## **Landscape and Visual Impact Assessment - Review**

**Dean Moor Solar Farm**

**Cumberland Council**

*Issue: Dean Moor Solar Farm LVIA Review\_FINAL\_170625*

Rev: N/A

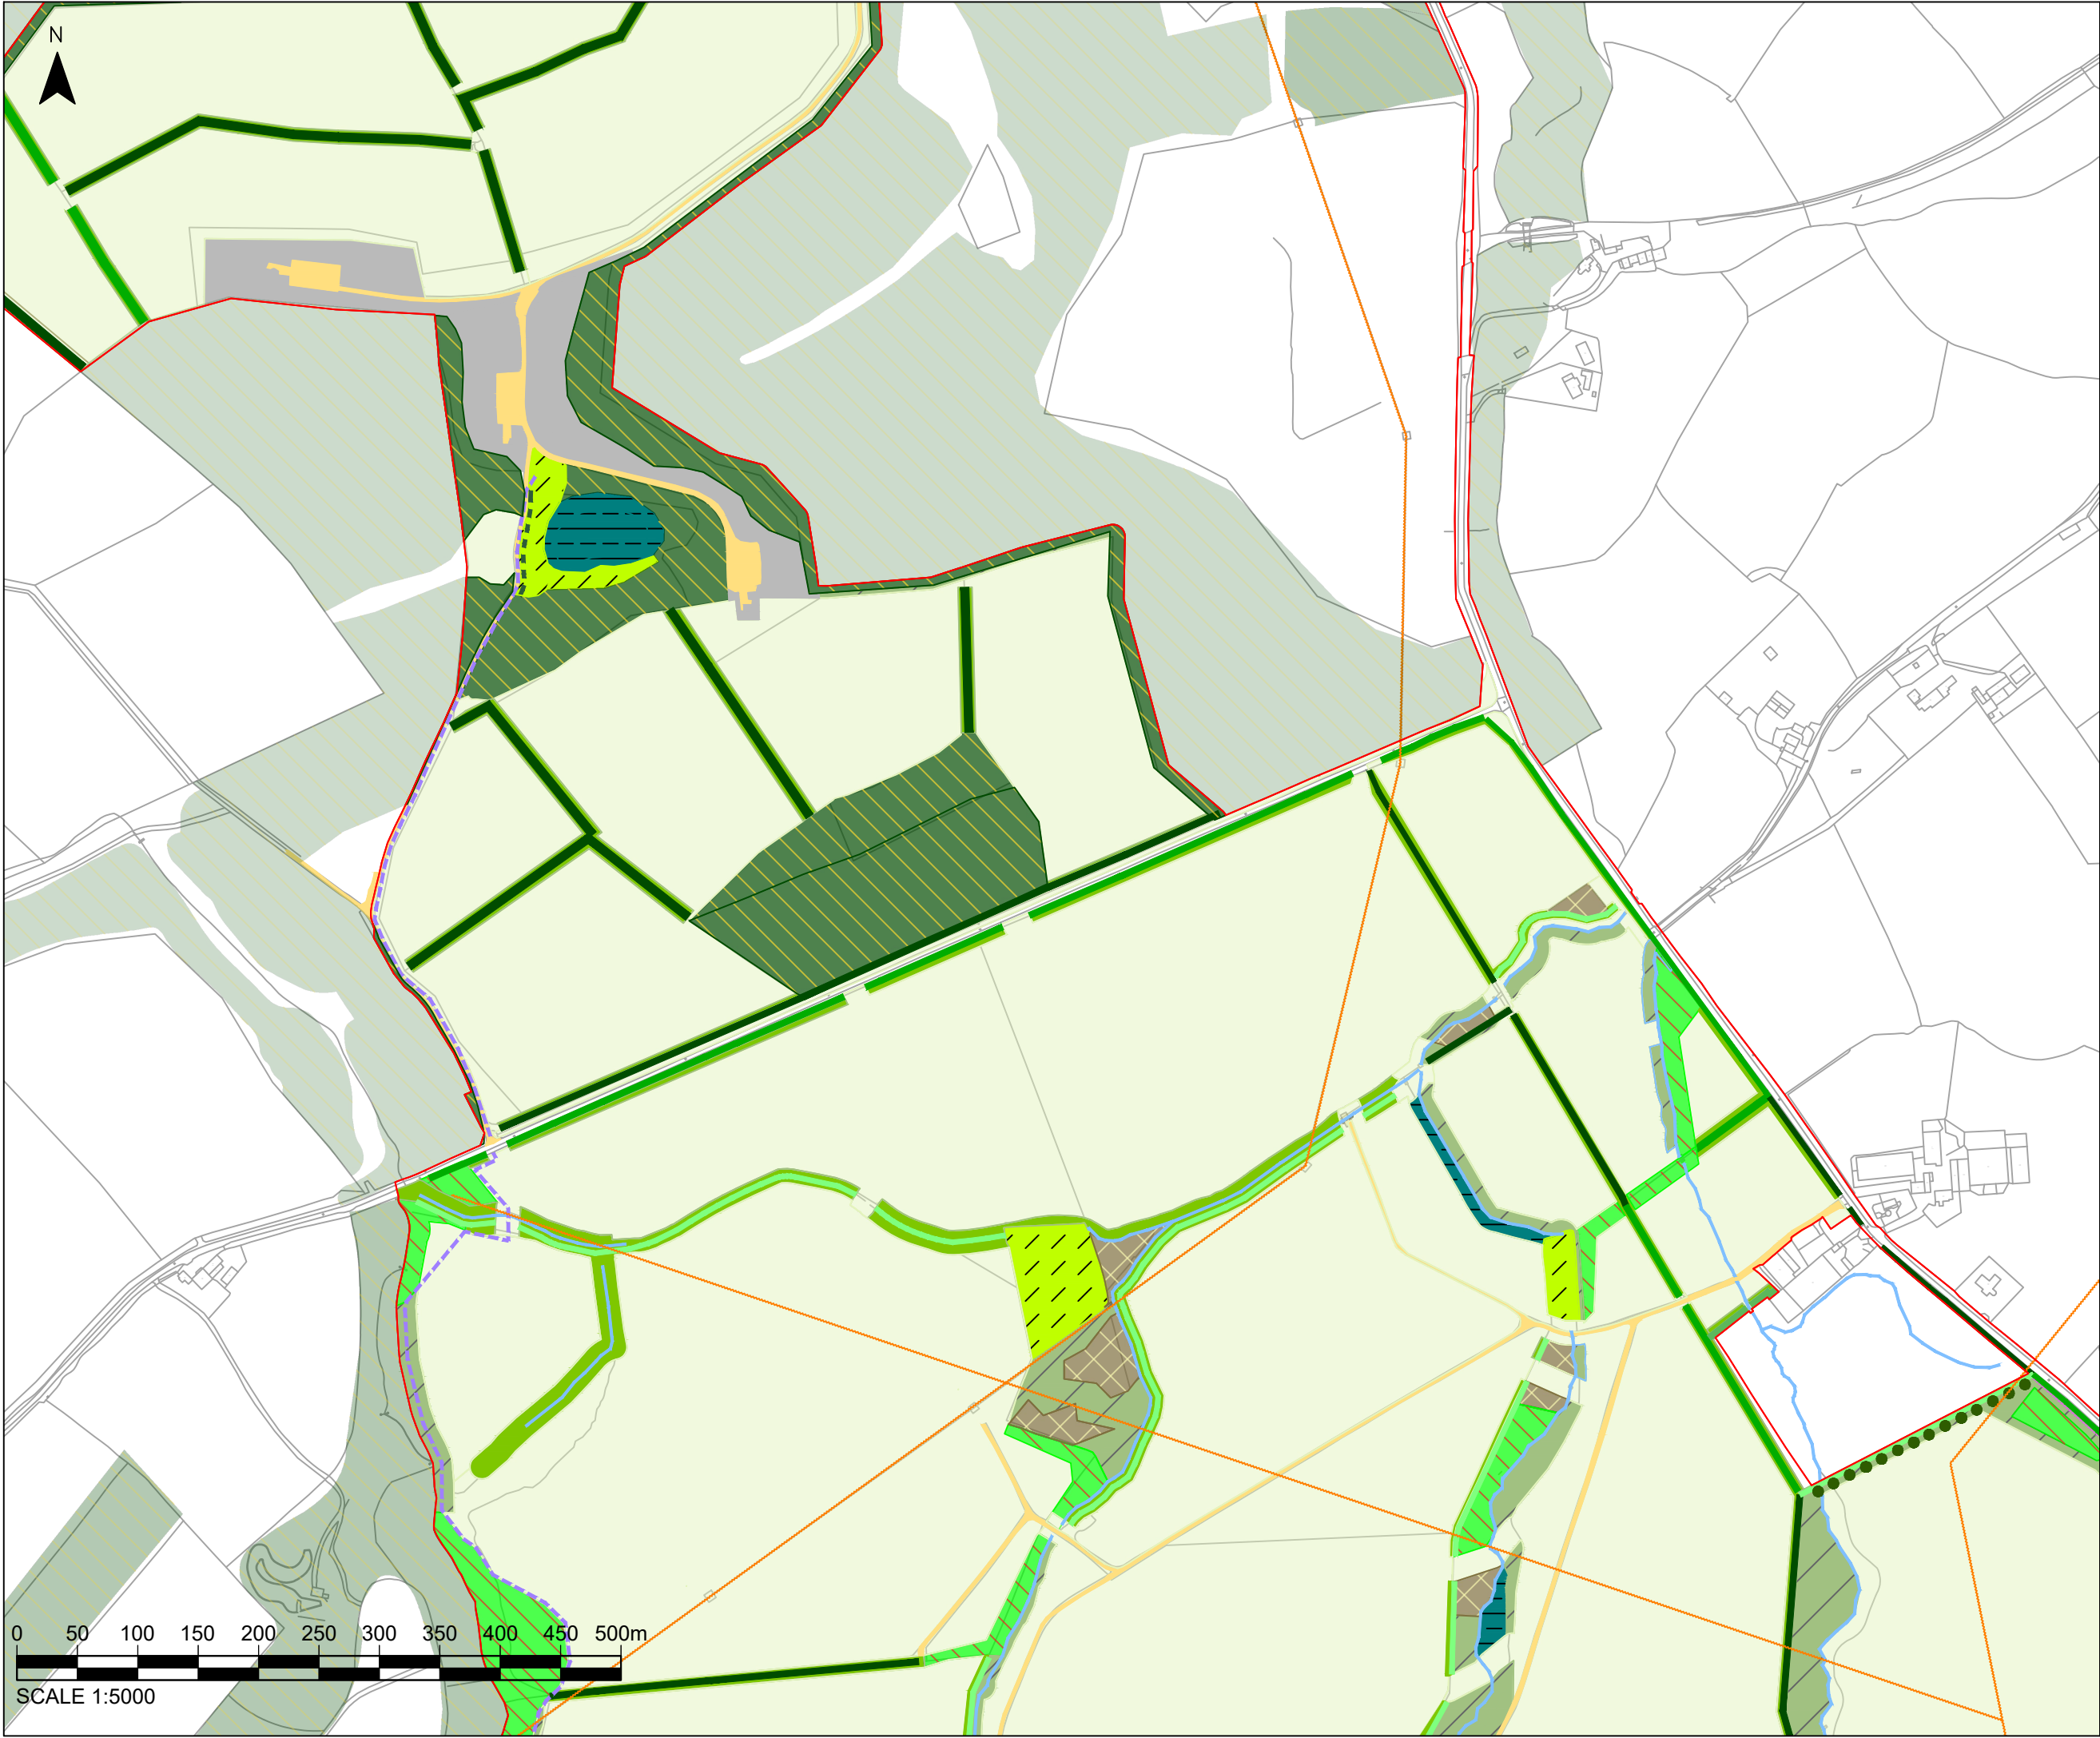
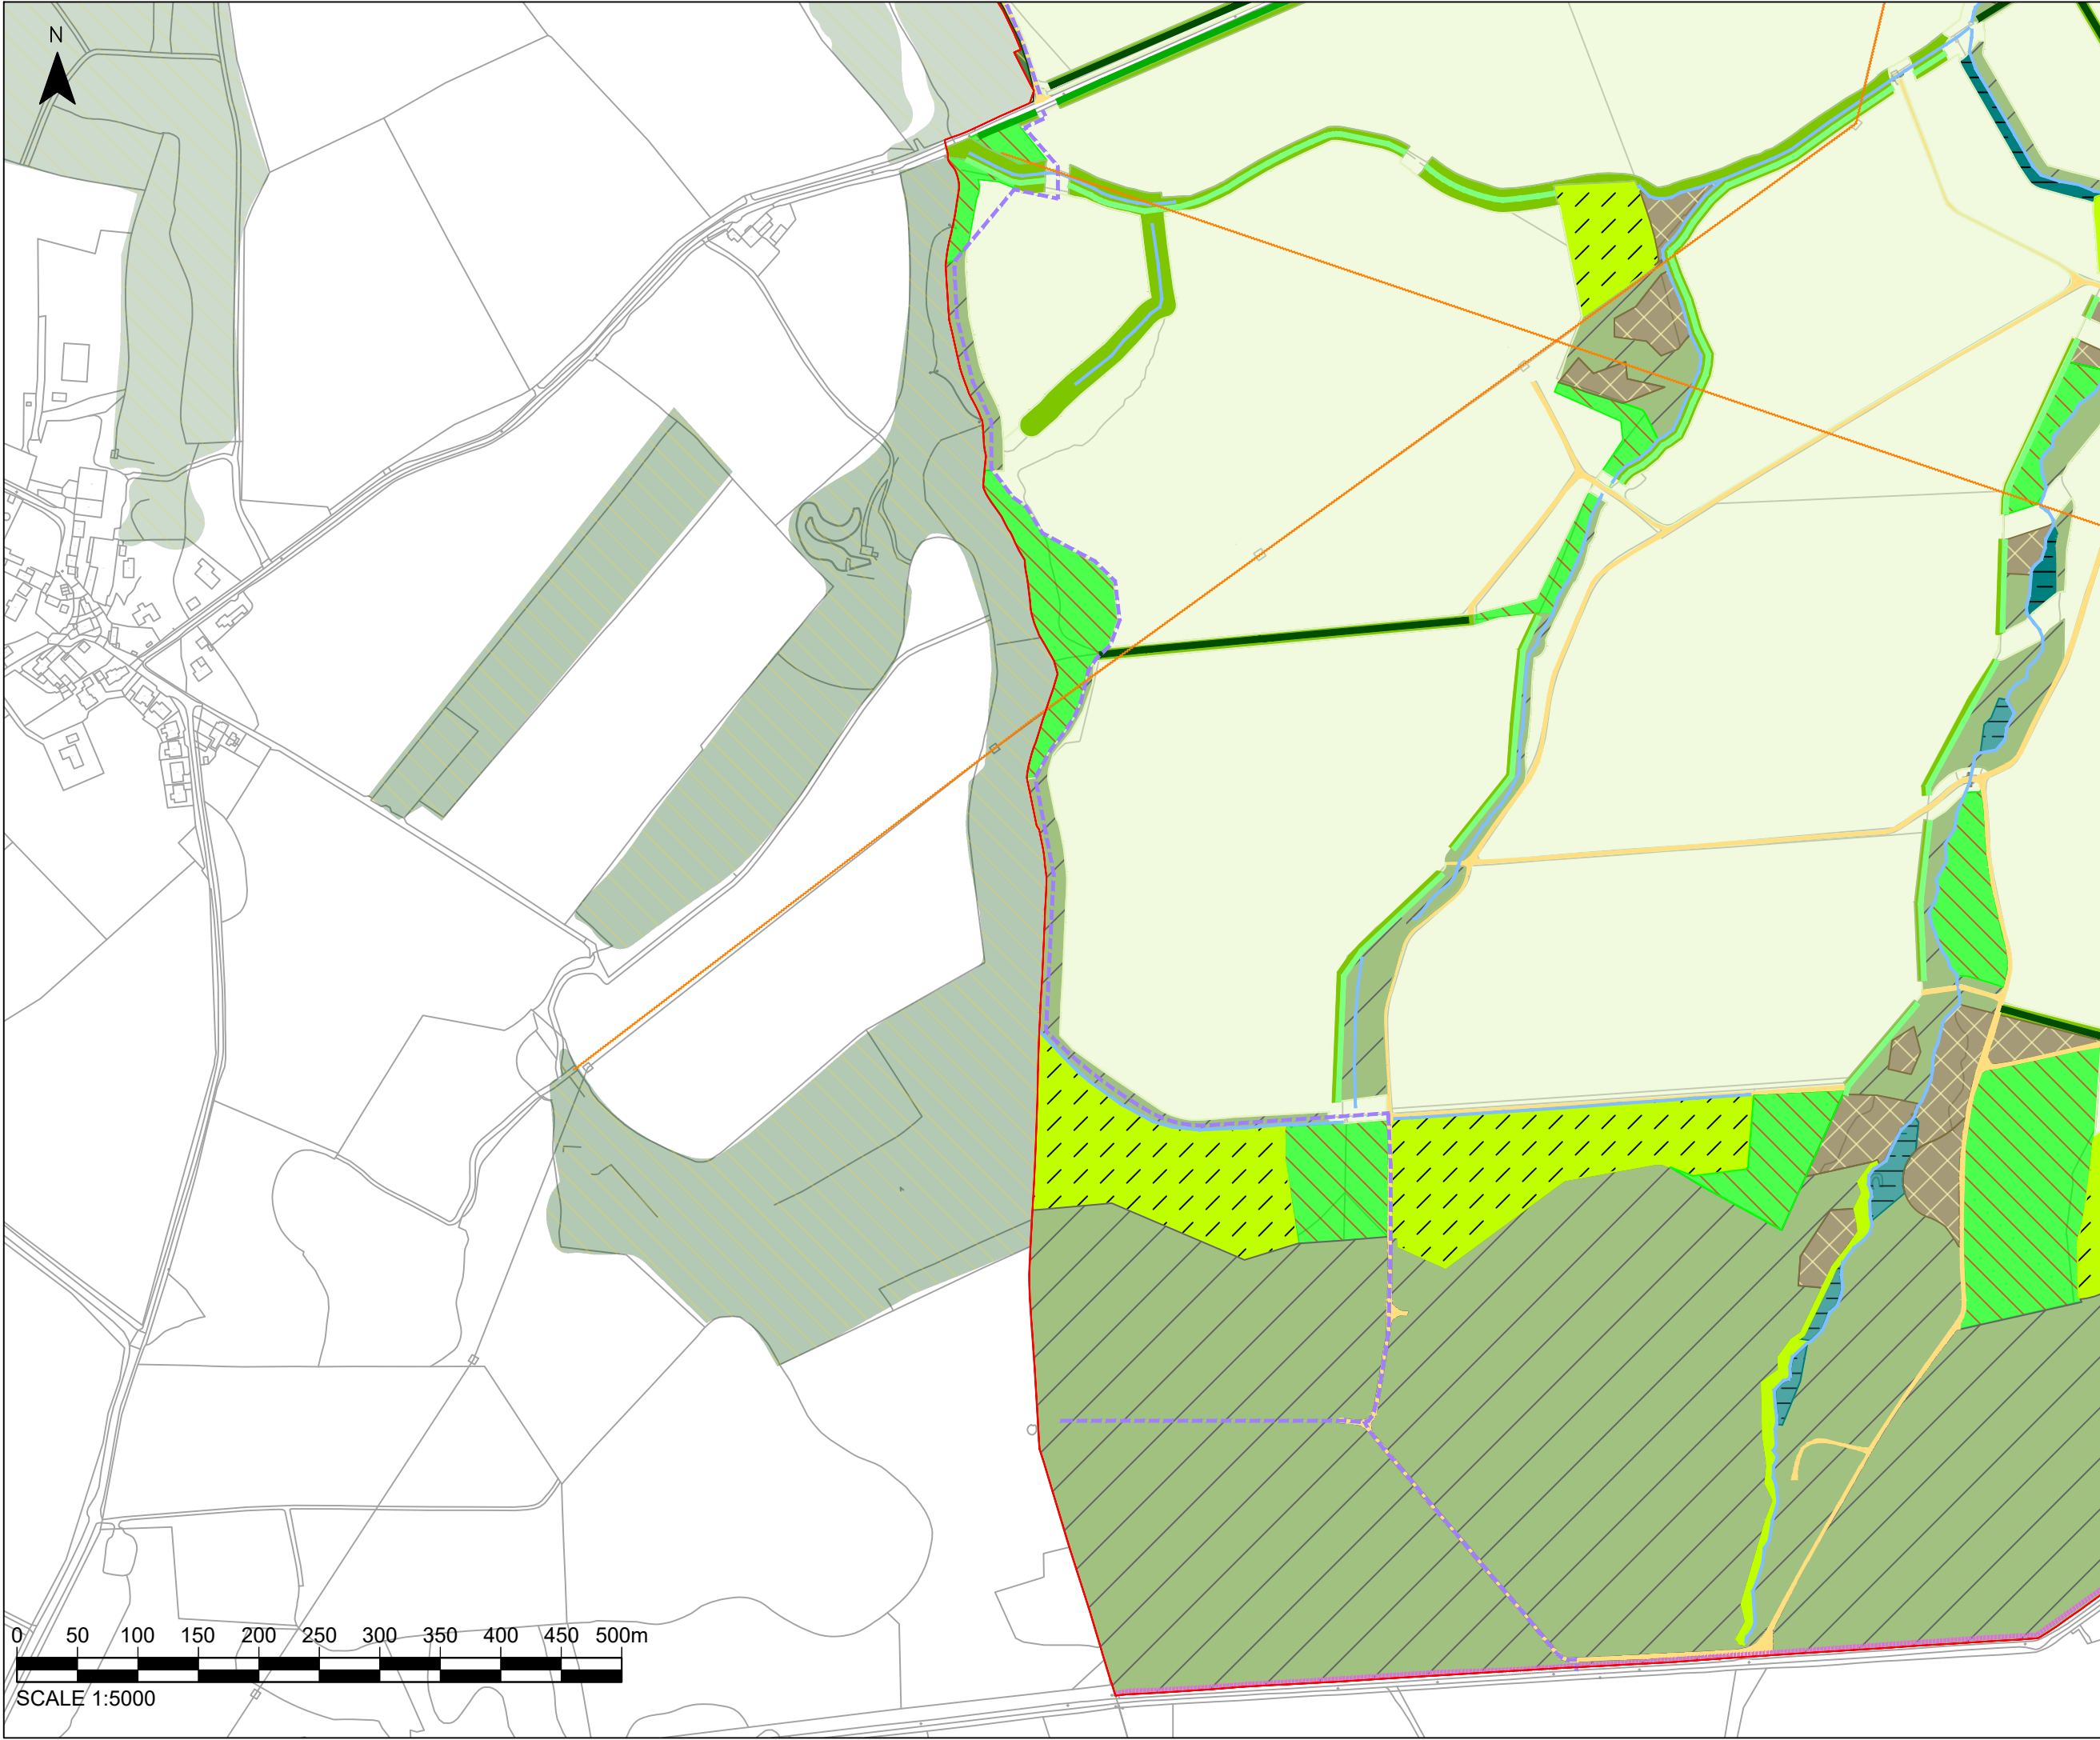
Mitigations proposals are shown in the Landscape Strategy Plan (Figures 7.6.15) and described in para 7.5.3 of the submitted LVIA.

The mitigation measures proposed seek to strengthen the existing landscape features where possible. This includes the infilling and enhancement of existing, enhancing existing woodland and scrub areas as well new woodland planting (along road edges (in the north) and watercourses in the southern area. There is also some hedgerow tree planting along Branthwaite Edge Road on the eastern boundary. These measures would, over time, help to reduce the visibility of the Proposed Development by screening views from the roads which run adjacent to the Site. Further planting of extra woodland and/or hedgerow trees would be suitable along the west of Branthwaite Edge Road.
